CITY OF ALBUQUERQUE

June 15, 2015

**RE: Starbucks and Burger King, Tract 338-B, 1000 Rio Grande Blvd. SE
Grading and Drainage Plan
Engineer's Stamp Date 5-16-2015 (File: H13-D021)**

1000 AND 1010 RIO GRANDE BLVD., NW GRADING AND DRAINAGE PLAN

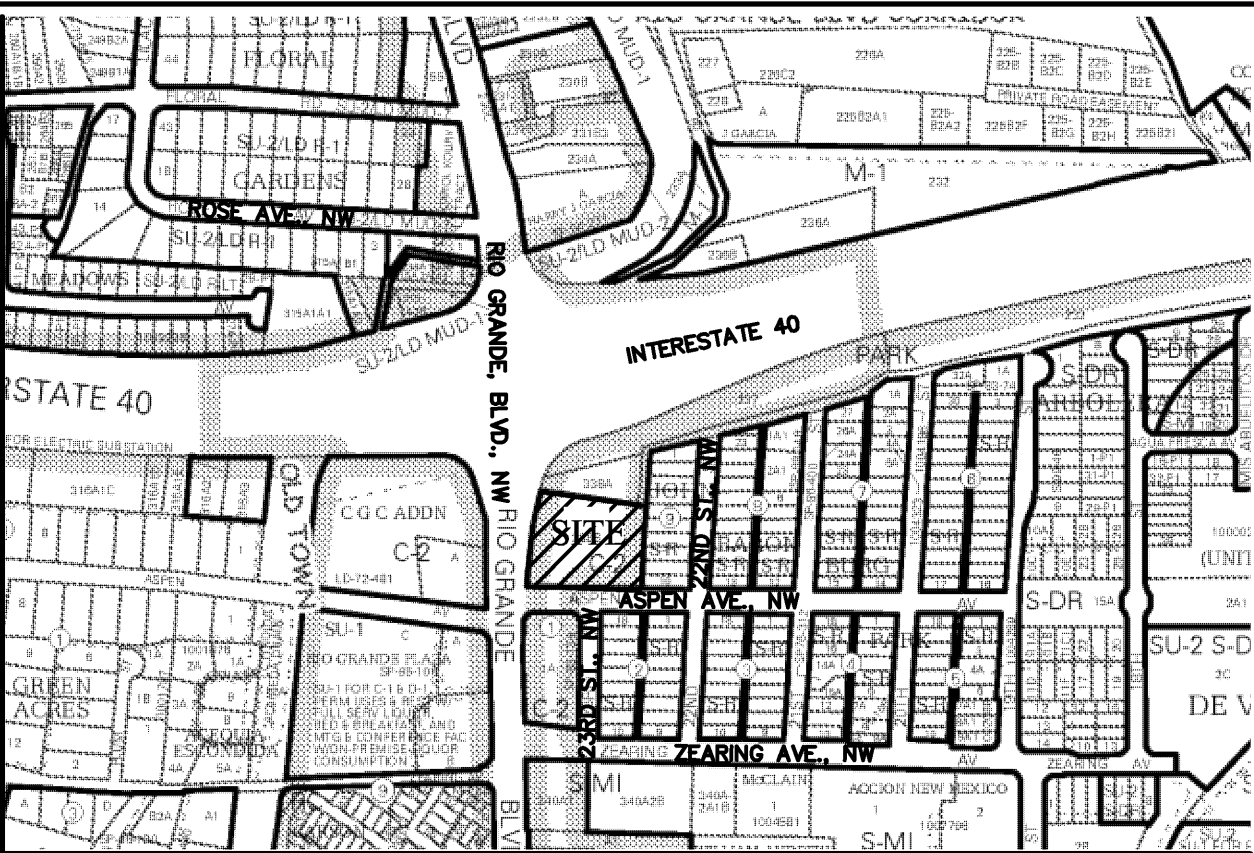
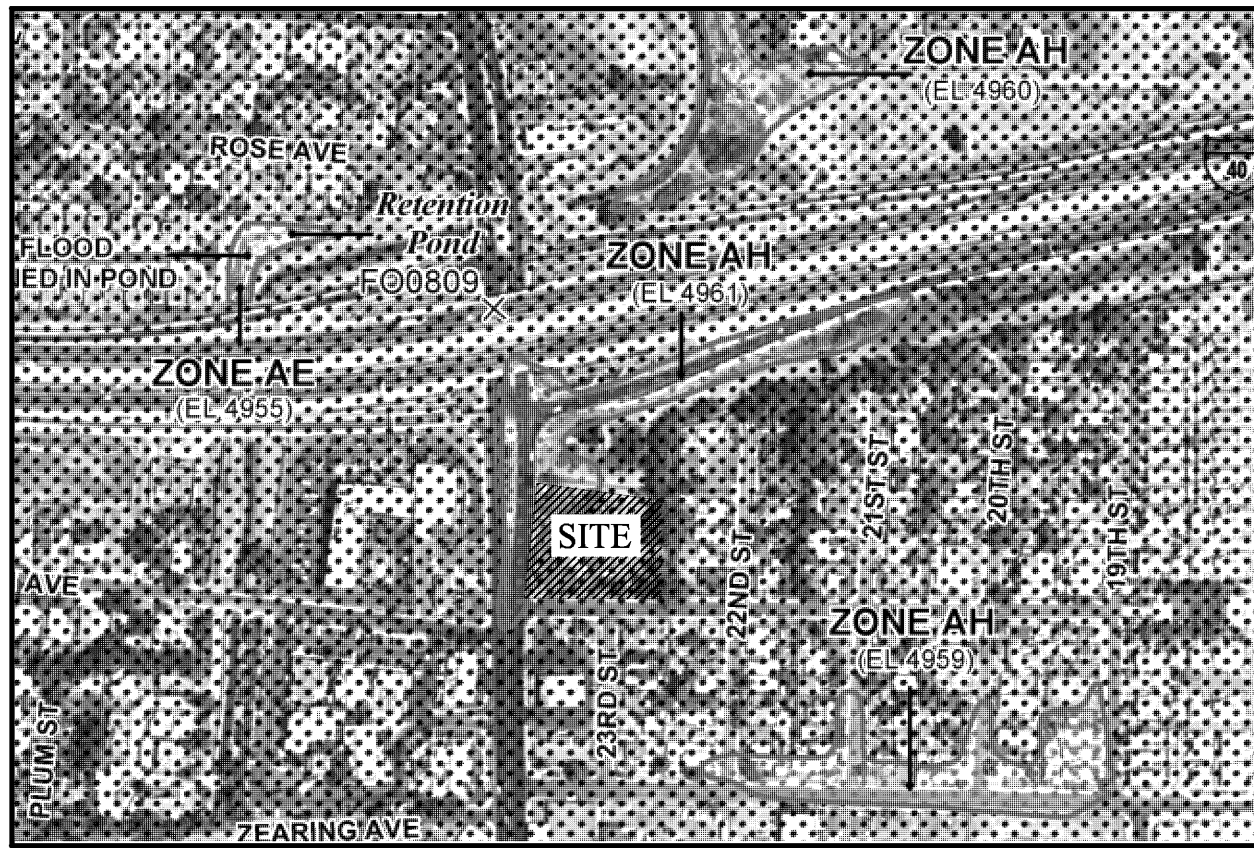
- 1) If the curb cut at the accessway is allowing discharge from Pond D, label the swale from this pond to the 61.65 elevation, delineating a clear path for stormwater to spill from the pond.

- 2) Provide a small section of riprap downstream of the curb cut within the swale at the north boundary of the site (Elevation 62.15) where flow is being collected from the north building in order to prevent site erosion near the property boundary.

- 3) Text for "Irrigation Pipe not to be Disturbed" is cut off on the right side of the plan view.
- 4) The 92.75 elevation shown within the parking lot at the corner of one of the handicapped parking spaces is in error. I think it was meant to put "62.75"?

- 5) Provide a grease trap to collect storm drainage from the trash dumpster area.
- 6) Make sure that the write-up matches what is shown on the plan view. The write-up is still referencing 6" pipes instead of 12" pipes, and it is still showing that inlets are collecting flow where there are none.
